# ENG-CDR21010-R4-GEC.pdf Markup Summary

**Subject:**  
**Page Index:** 1  
**Date:** 6/21/2022 11:37:22 AM  
**Author:** dsdrice  
**Color:**   
**Layer:**  
**Space:**  
**Page Label:** [1] 1 2518800 Vollmer North GESC-CV01 -  
Vollmer GESC CV01

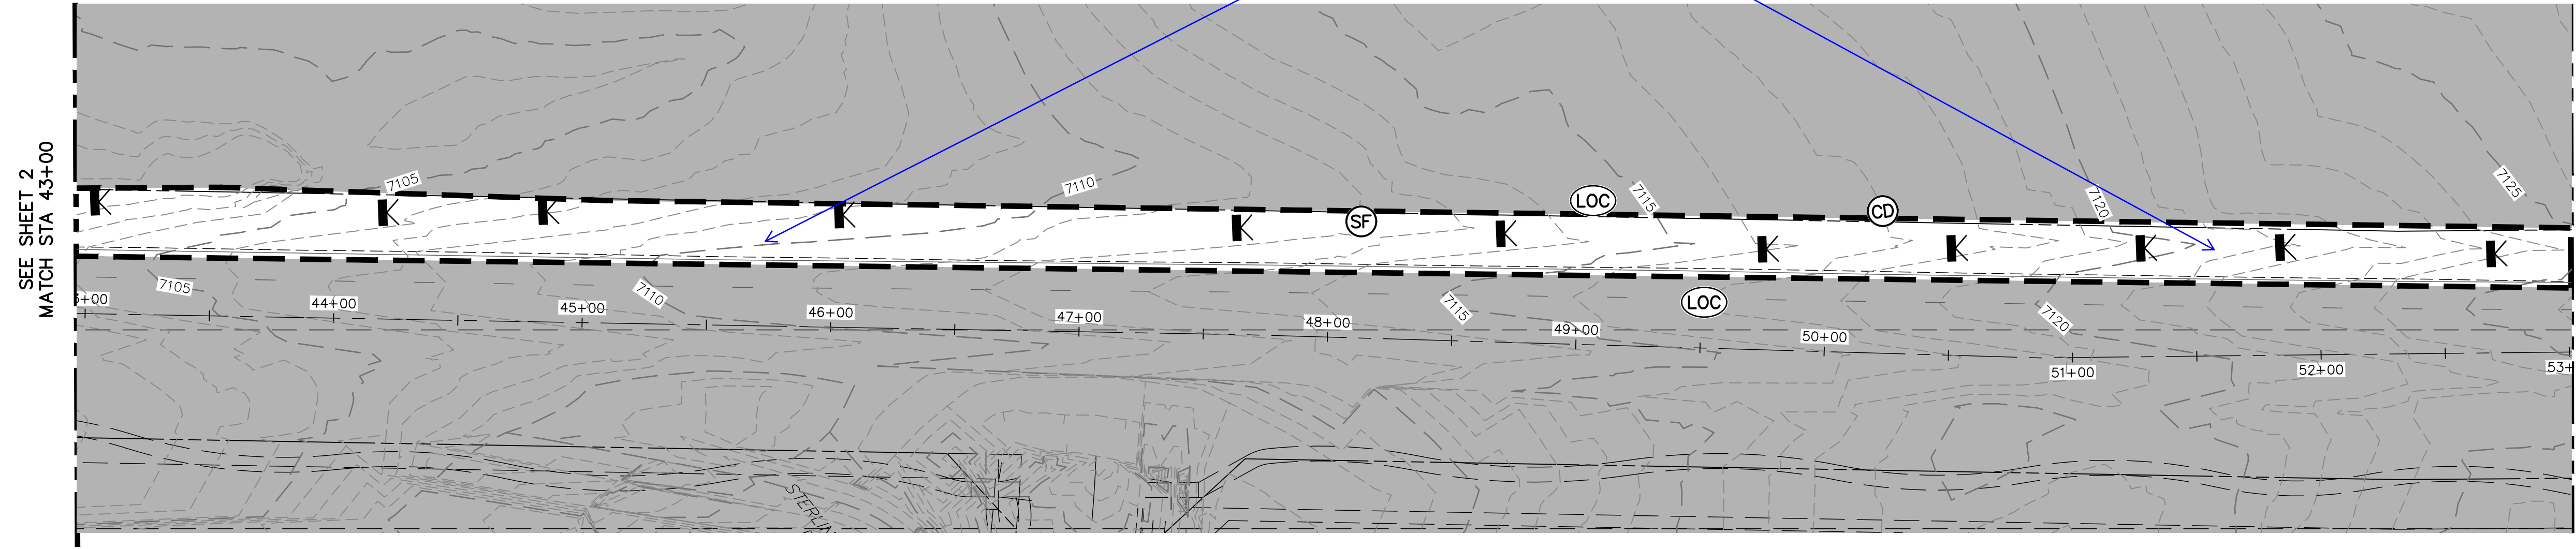
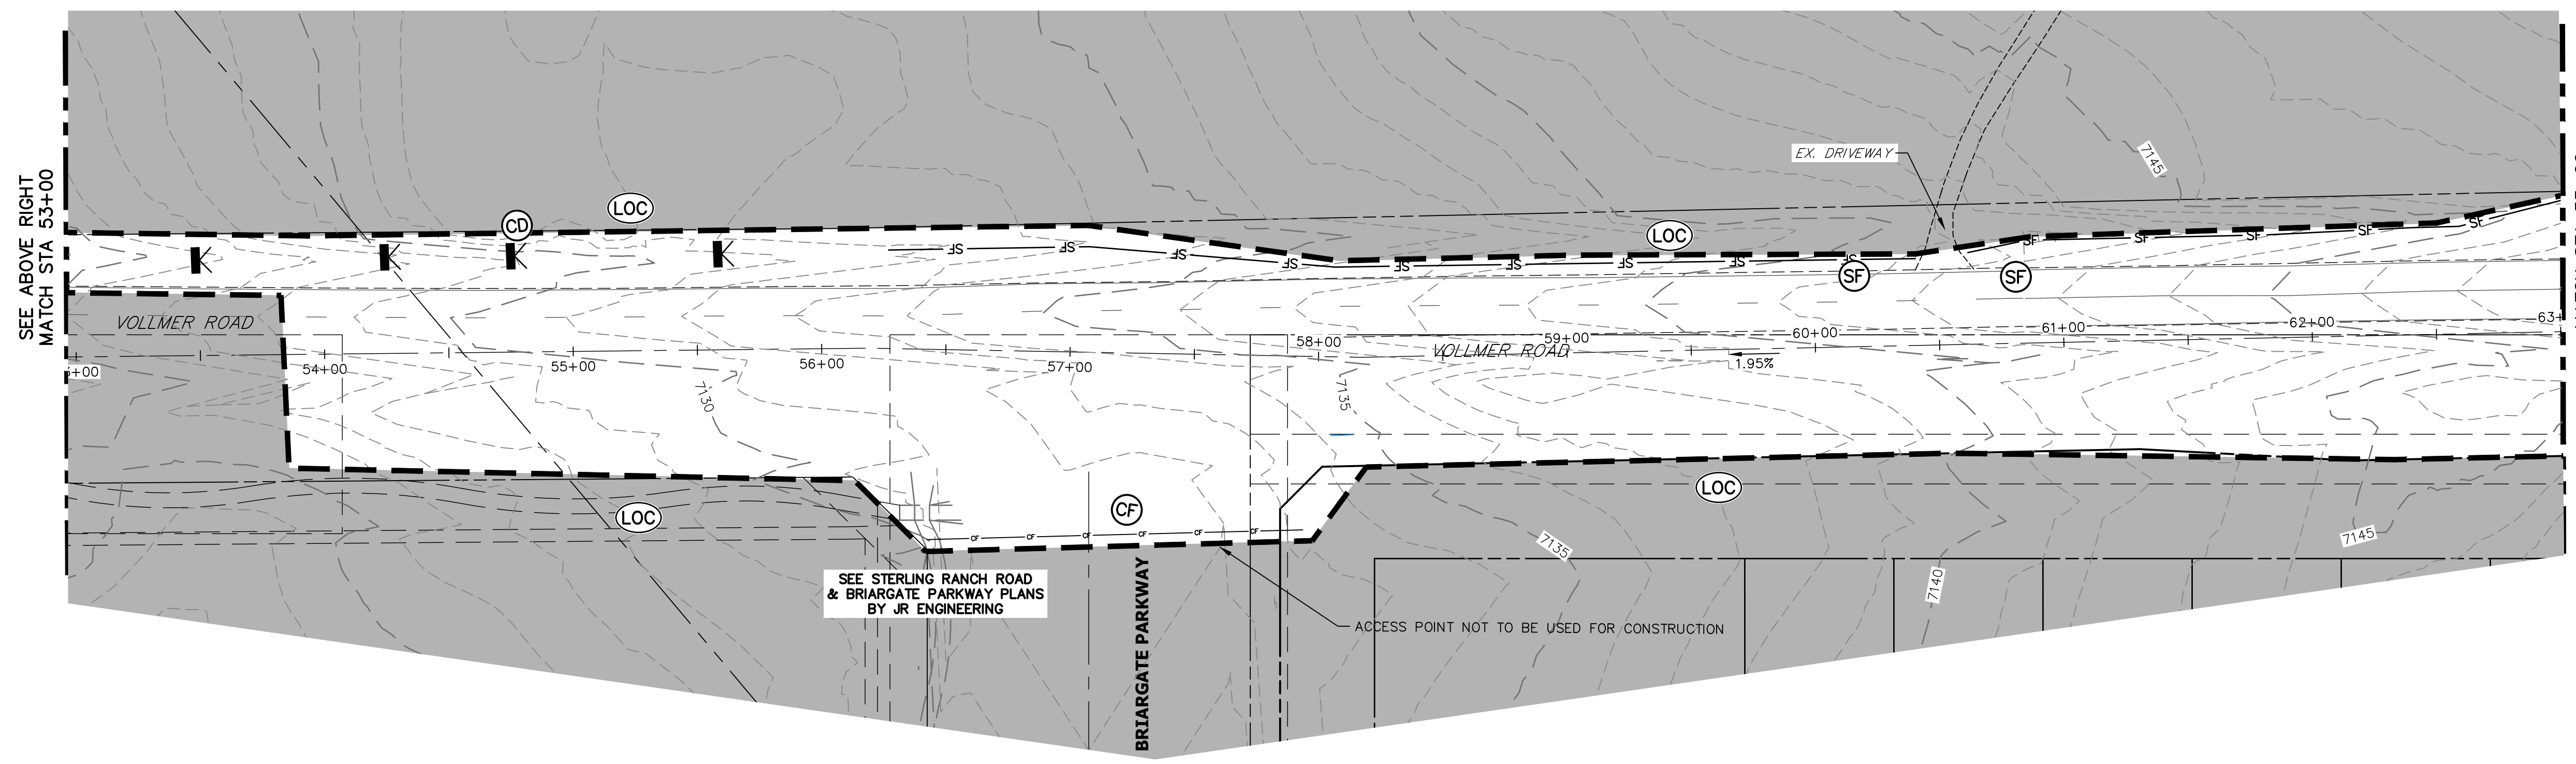
Add a couple flow arrows

<b>VOLLMER ROAD (NORTH)</b>	<b>GRADING AND EROSION CONTROL INITIAL PLAN</b>
SHEET 4 OF 16	JOB NO. 25188.00

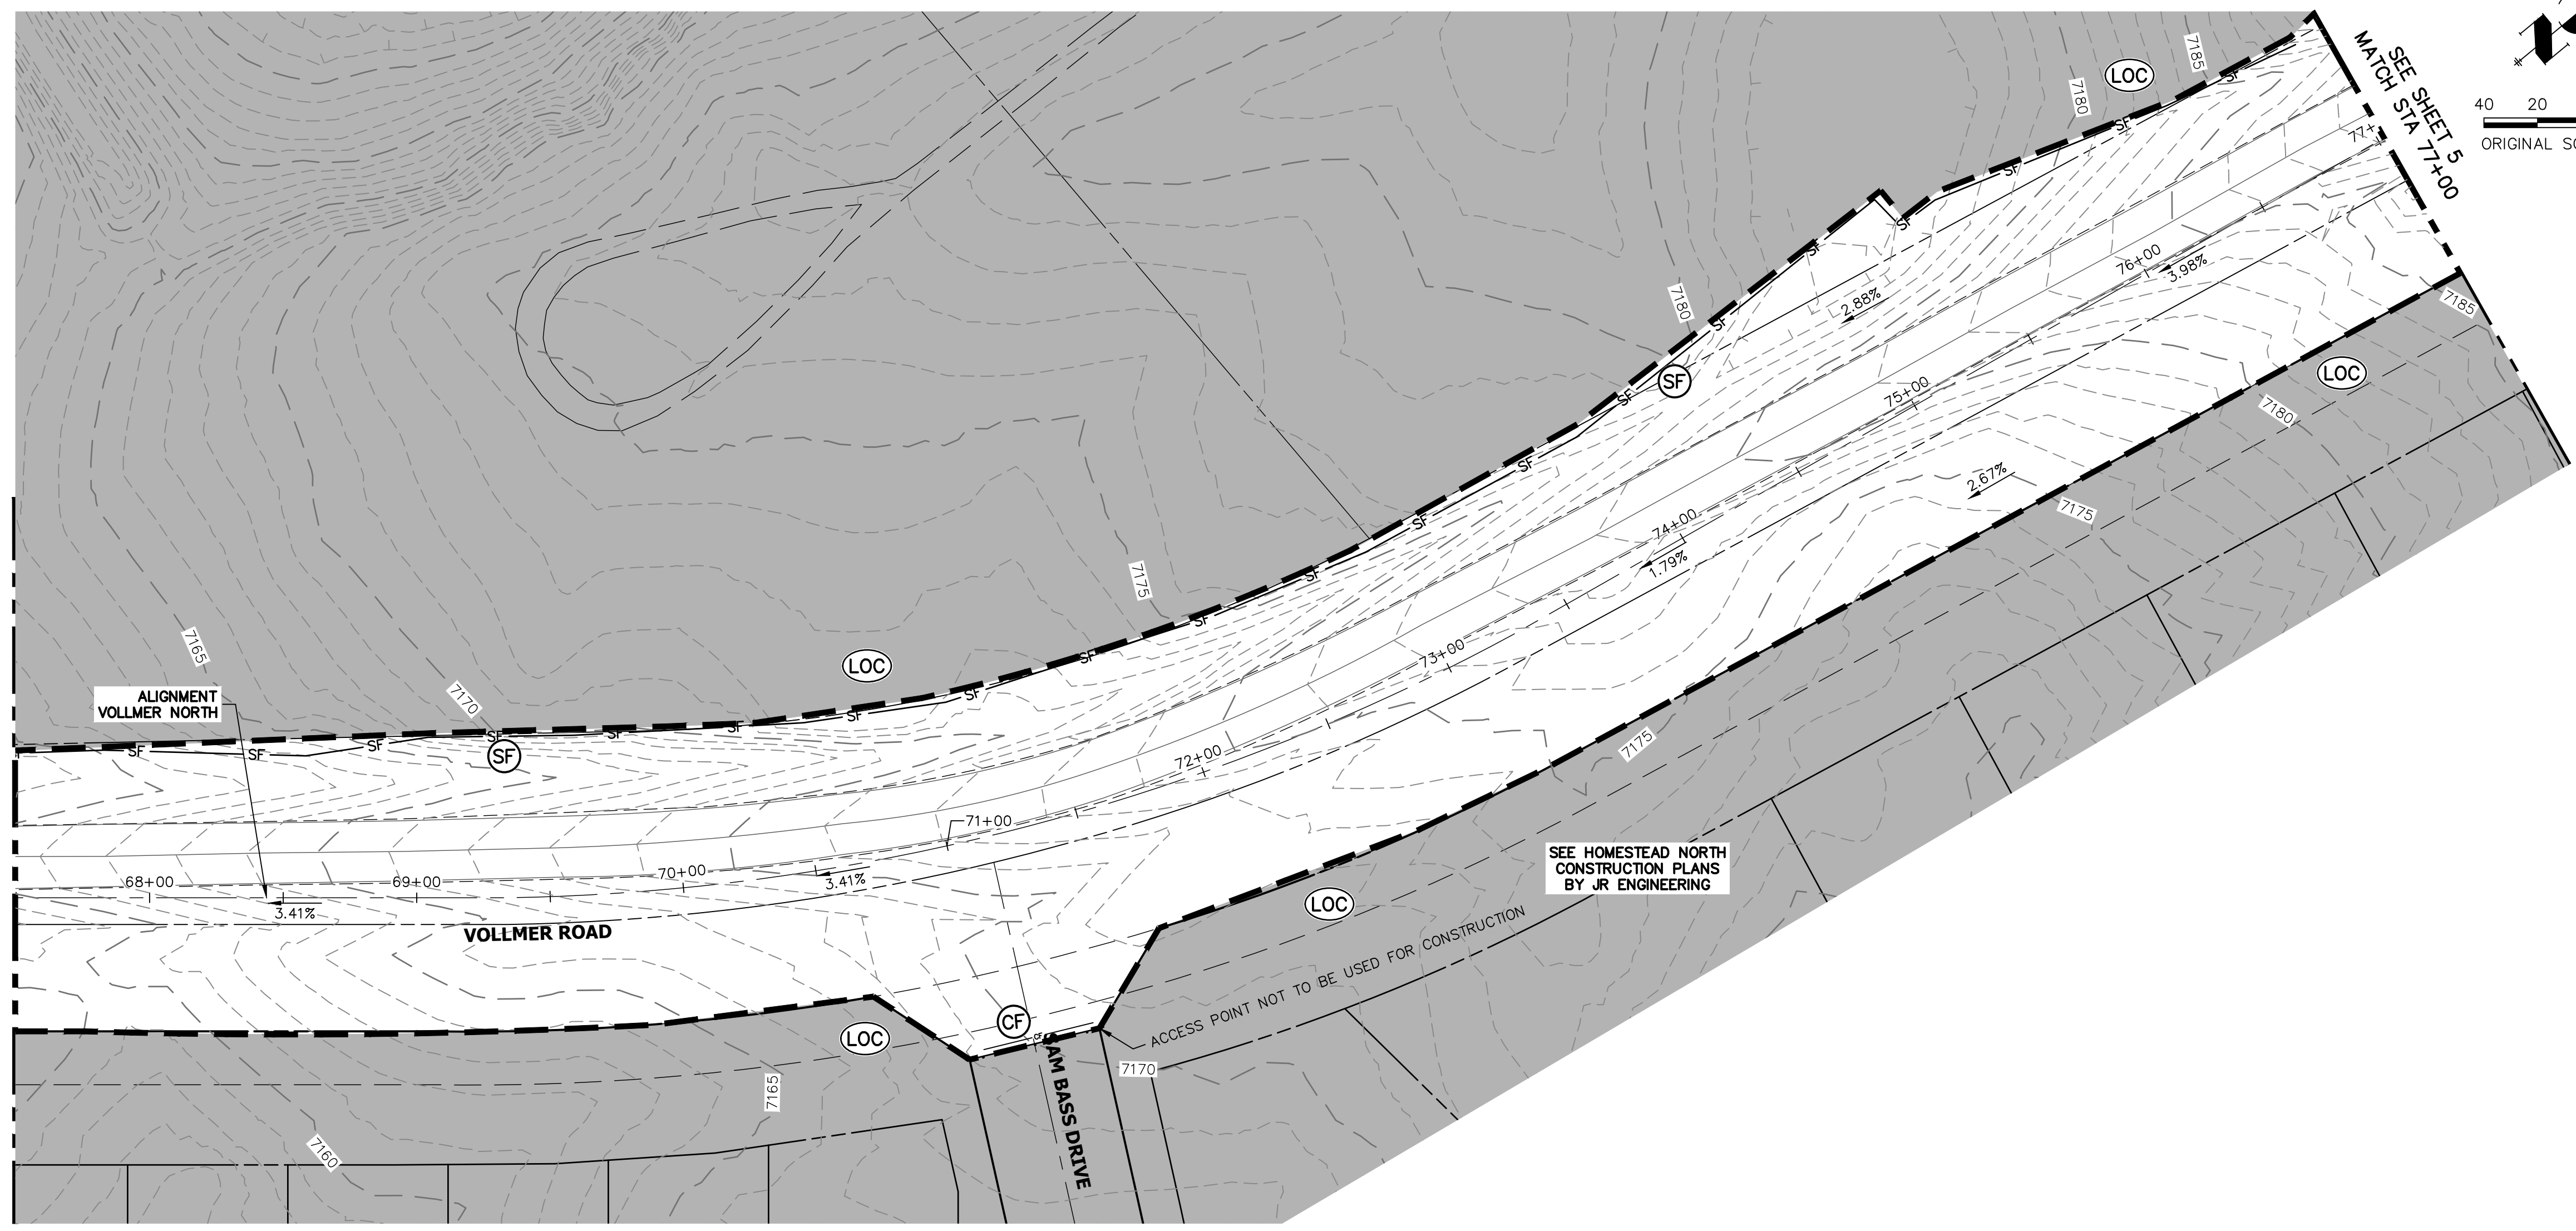
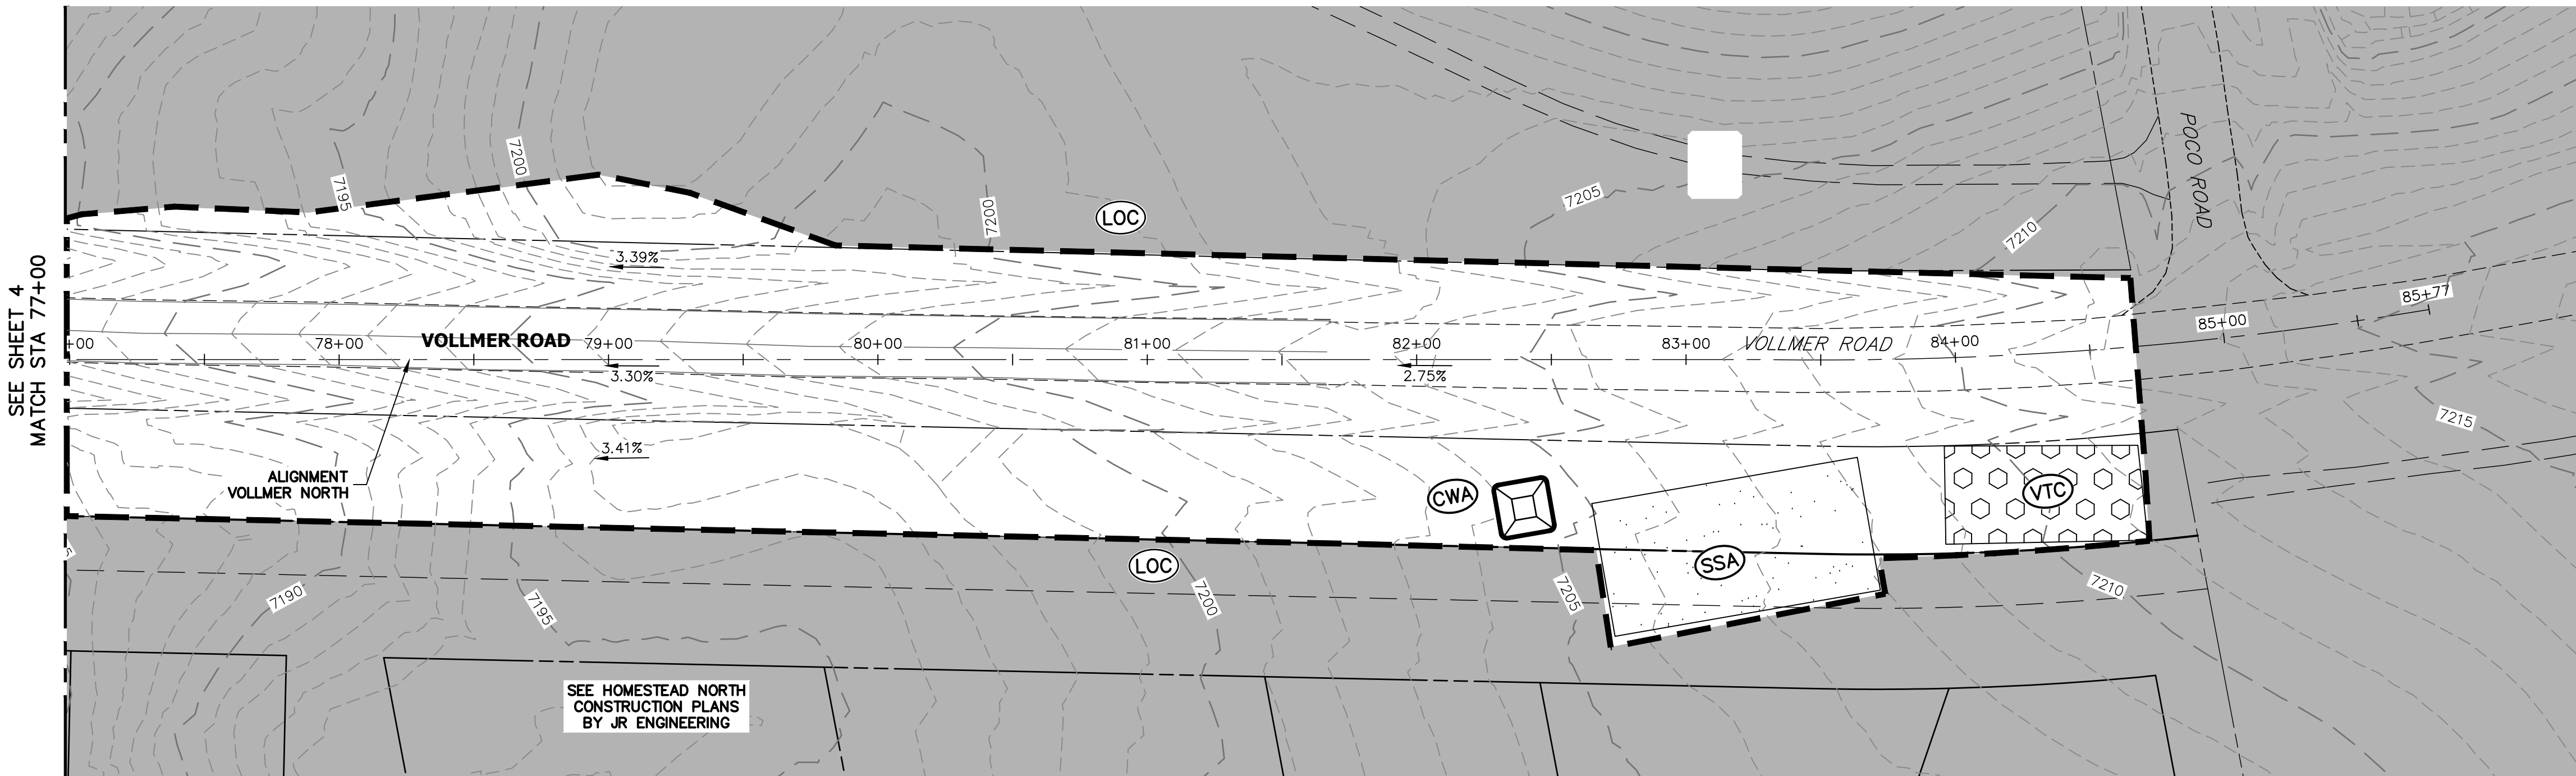
Add a couple flow arrows
